PROW Planning response 2025/0942 Change of use – TPT Stairfoot car works

Transportation have discussed this proposal with the PROW manager prior to it being submitted for planning consent.

View 4

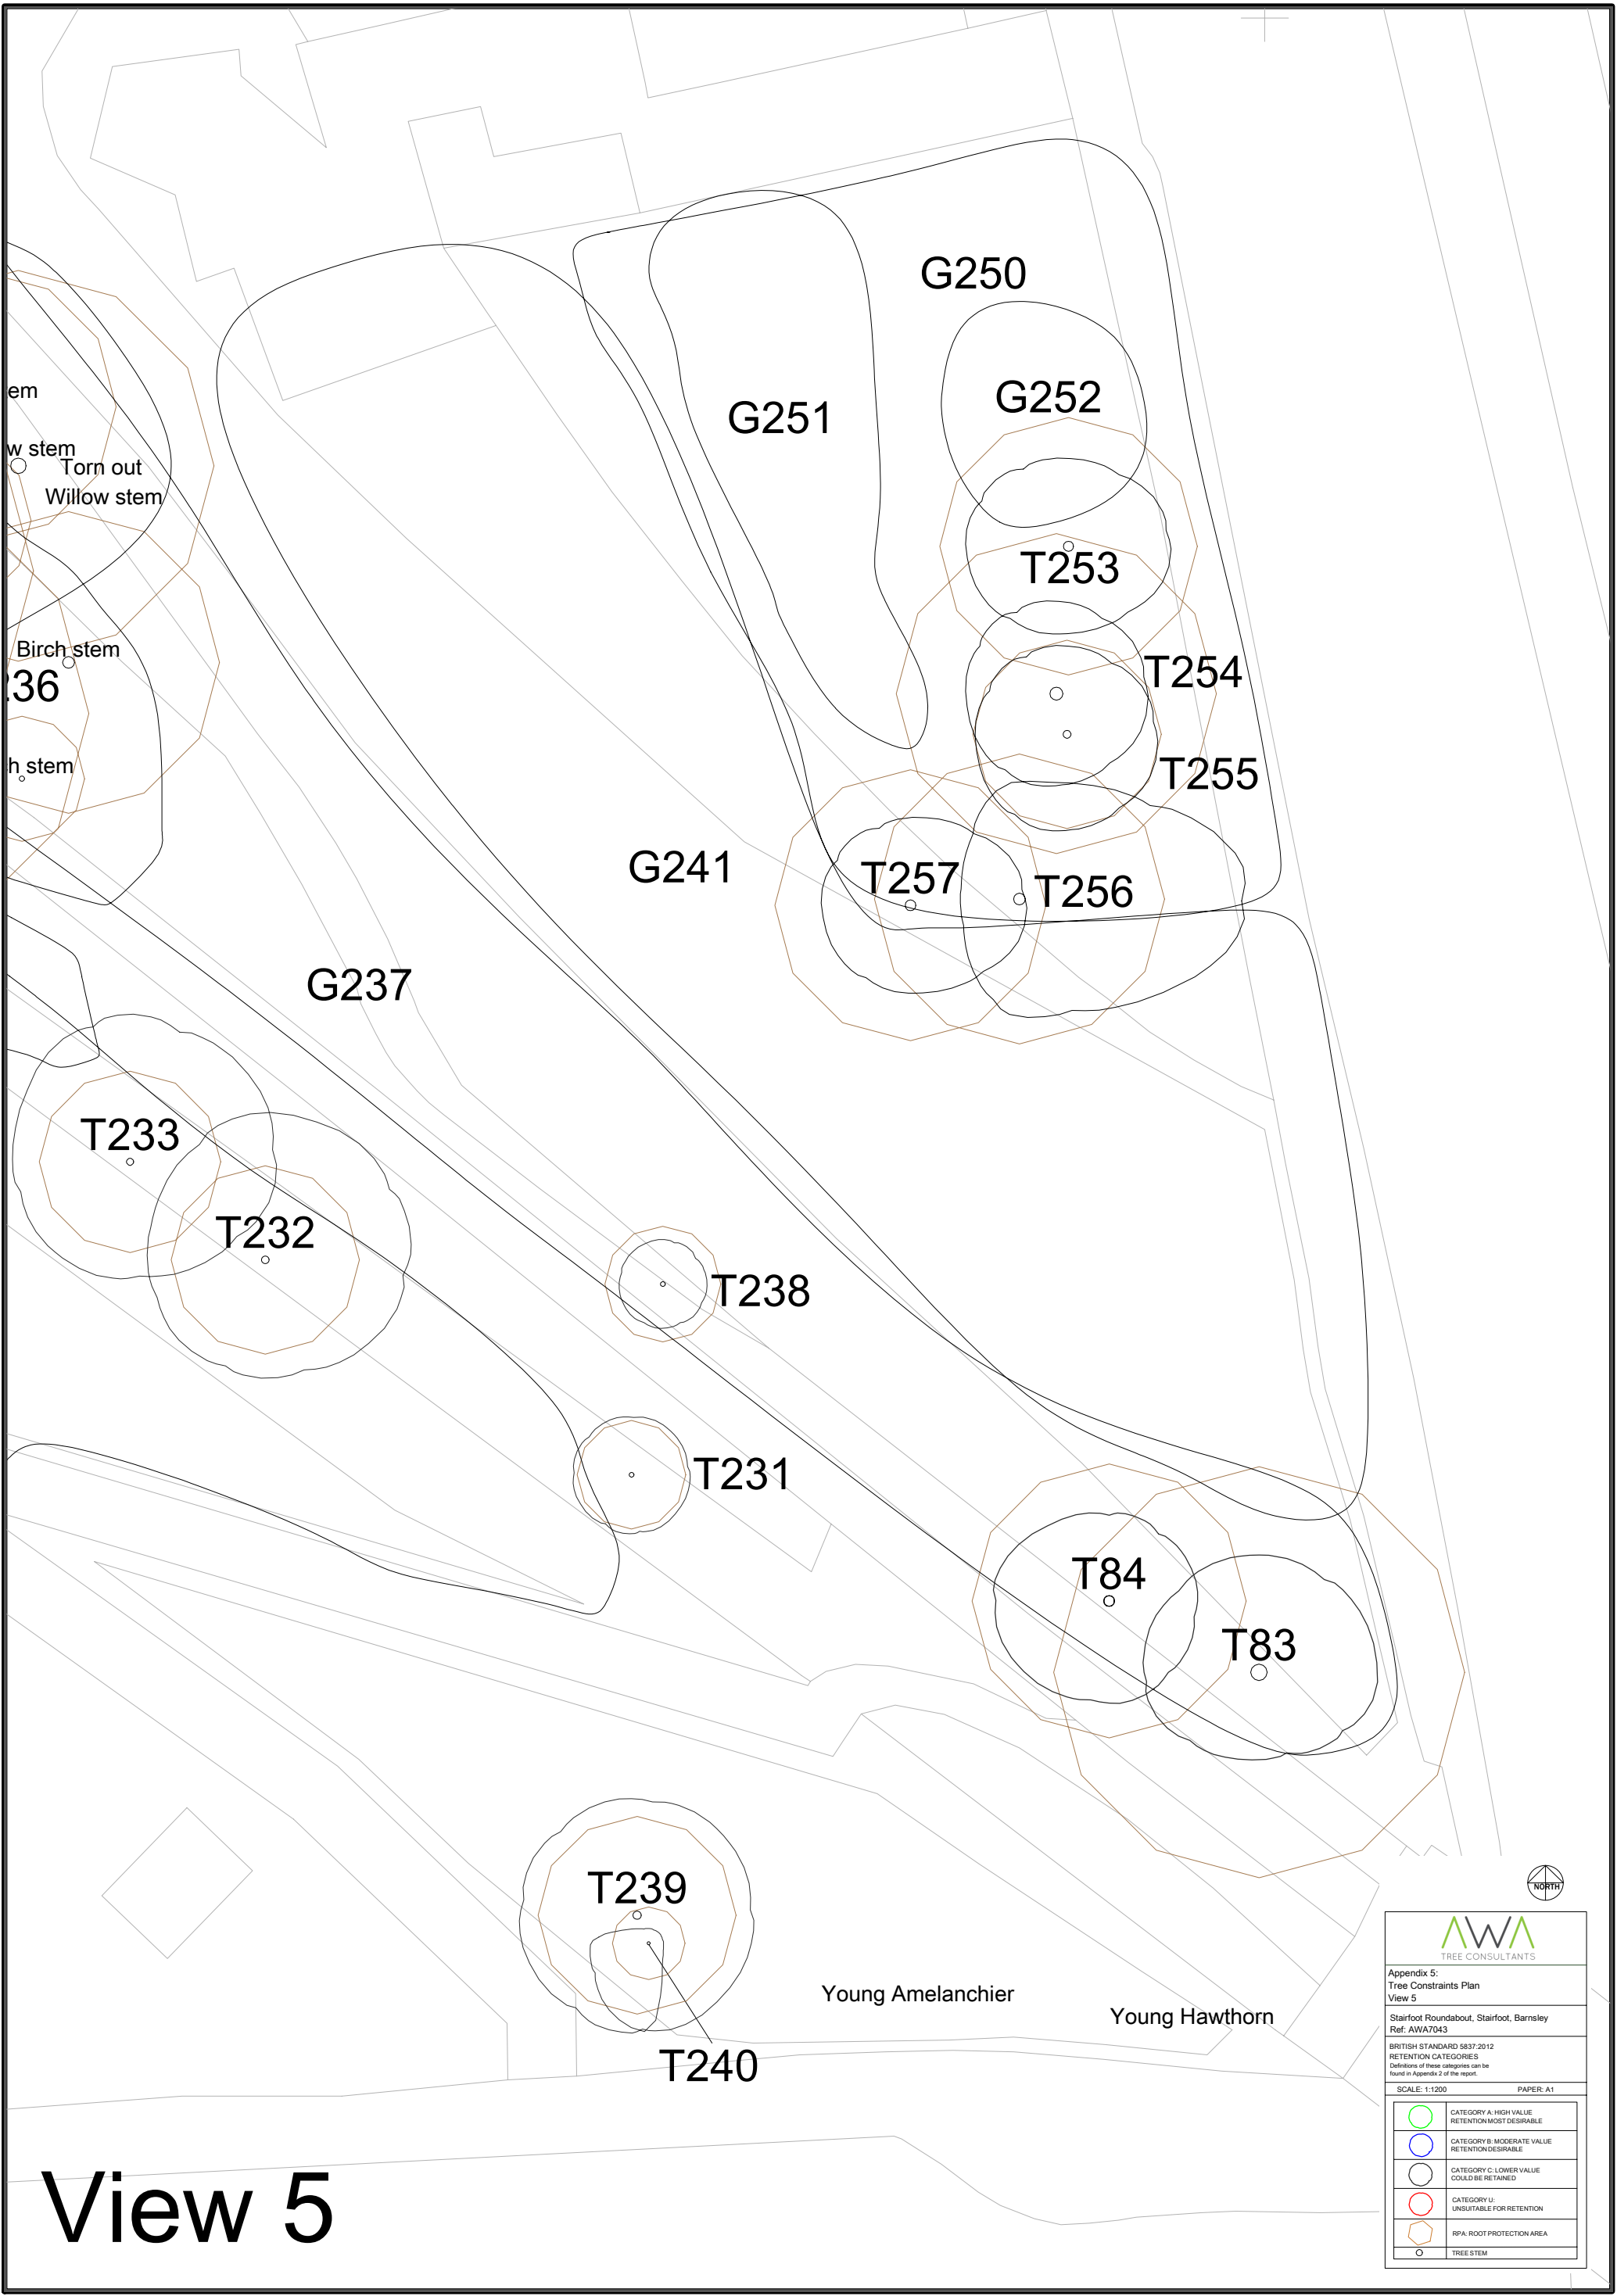
In the preparation for this planning application we asked if cutting back could be considered on the other side of the Trail by the S bends to provide improved sight lines for users coming round the corners. This would be G130 on the Arbo plan (extract below) and would be classed as maintenance of the public highway (which includes bridleways) under our management powers

Looking at the Arbo report there appears to be an error around the corner tree recorded on the extract above as T31. It seems out of number sequence and there is no corresponding line within the spreadsheet for T31. There is a G31 but that is for a group. There is also a T131 on the other side of the Trail already in case there is a number missing.

What ever T31 should be along with T134 and T135 have root protection areas that appear to be within or in very close proximity to the new fenceline. How is that going to be addressed?
